HINCKLEY NATIONAL RAIL FREIGHT INTERCHANGE

Project reference TR050007

Applicant's response to Deadline 7 Submissions [part 2 - HBBC]

Document reference: 18.21

Figure 12: Suggested DRT based Service Zone (source: Vectare)

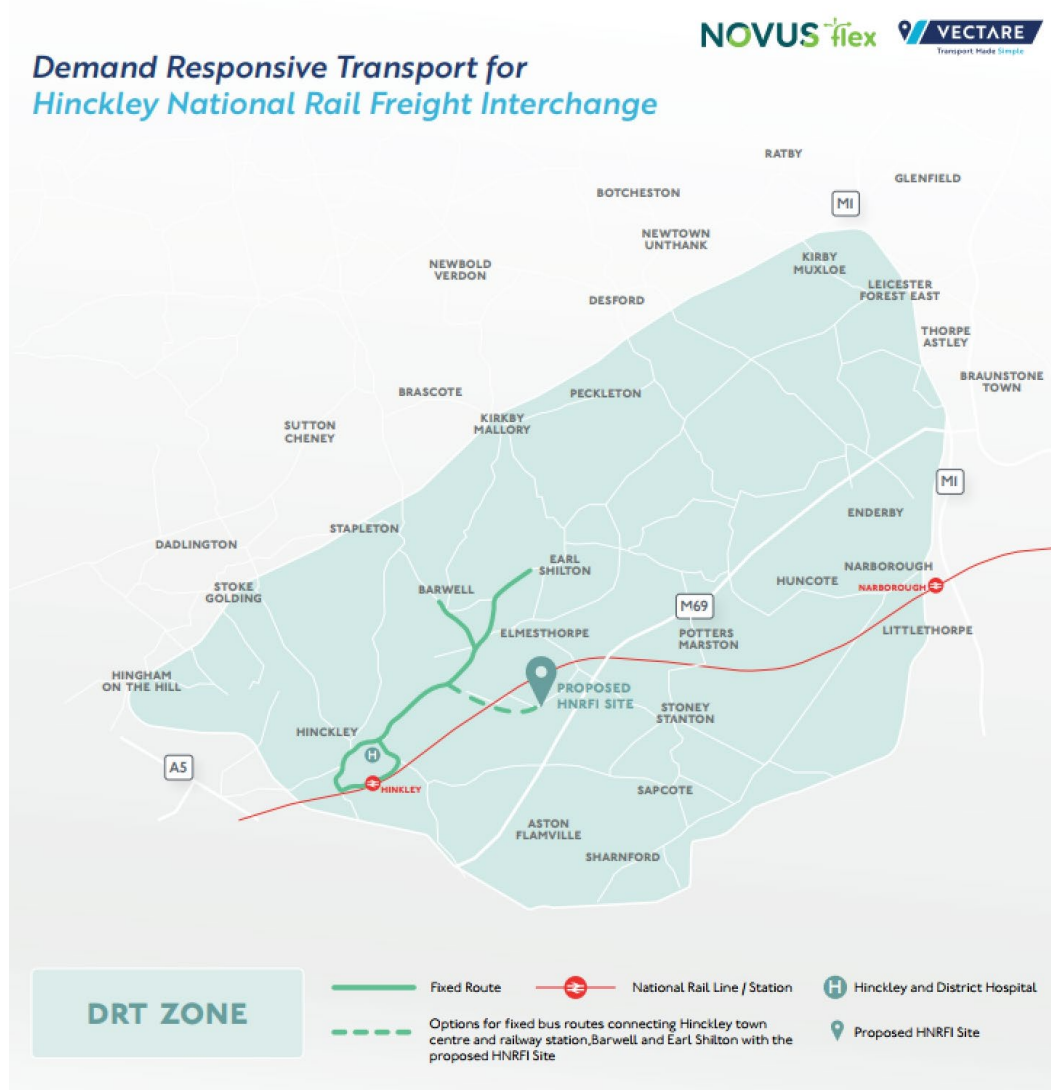
Document and Section Reference	Hinckley and Bosworth Borough Council Response	Applicant's Response
ES Appendix 8.1 Transport Assessment [Part 15 of 20] Sustainable Transport Strategy and Plan Document Ref 6.2.8.1D Revision 08		
<p>Table of Commitments 4 - DRT</p>	<p>The Council continues to express concern about the proposed DRT solution for public transport in most of Hinckley, Earl Shilton, Barwell and the Blaby. The applicant could easily have recommended a bus service to serve these areas, and the latest commitment changes do not allay the Council's concerns.</p> <p>The only change the Council have noted is that the applicant has now committed to allowing a 24-hour advance booking for DRT passengers; other passengers for DRT can still book but will have lower priority. However, the Council cannot see that a commitment can be given that these journey time requests will be able to be delivered. Given the local population which could be served by the DRT option there is the likelihood that there could be multiple demands from different locations all requiring the service at the same time in order to get to the start of a particular shift and under these circumstances there is the possibility of failure of the service.</p> <p>The Council has previously asked for a defined Level of Service for DRT – including catchment, journey time, fare, pick-up time – but this is still not available and without it the DRT is not a certain commitment. The service will pick up as many people as 1 bus can do at multiple locations, but journey and pick up times may be long and this will undermine patronage.</p> <p>An effective commitment would include a guaranteed Level of Service (LoS), with additional DRT vehicles being implemented if the LOS is not met (or backed-up by a funded taxi ride instead). That level of service should (1) guarantee of pick up within 20 mins of requested time (2) within 10 minutes' walk of any household in catchment (3) journey time of no more than 20 minutes (4) free fares for first 6 months, thereafter no more than the equivalent bus fare for that distance (5) from first occupation for lifetime of</p>	<p>As set out within the commitments table of the STS (document reference: 6.2.8.1E, REP7-028), the DRT Service and public transport service provision will be increased in line with the increase in on-site staff as the HNRFI becomes occupied. The commitments table sets out that the requirement for an increase in service provision is to be reviewed on an annual basis. The site will populate over a long time, so it is critical for monitoring to identify suitable provision.</p> <p>There is a memorandum of understanding with the DRT delivery company. The STS sets out how the DRT is proposed to operate and the level of service provision, this commitment to the service is contained within Table 1 of the STS (document reference: 6.2.8.1E, REP7-028).</p> <p>It is important to note that this service is a commitment that provides access to communities which have limited to no public transport provision. HBBC's preferred alternative of a dedicated bus service lacks the flexibility to cover the geography highlighted within the STS (document reference: 6.2.8.1E, REP7-028). As above, should monitoring indicate that a fixed route would be viable, based on repeated patterns of DRT journey then this can be considered in tandem with the provider. This has happened at Lubbesthorpe for example. At this stage the employee catchments are based on best estimates, a fixed route in dispersed rural communities is not a viable solution without the actual demand being known, this also applies to the level of service. The DRT provides a good solution which can be built upon as the site develops and has incentives to encourage its use from Day One of occupation.</p>
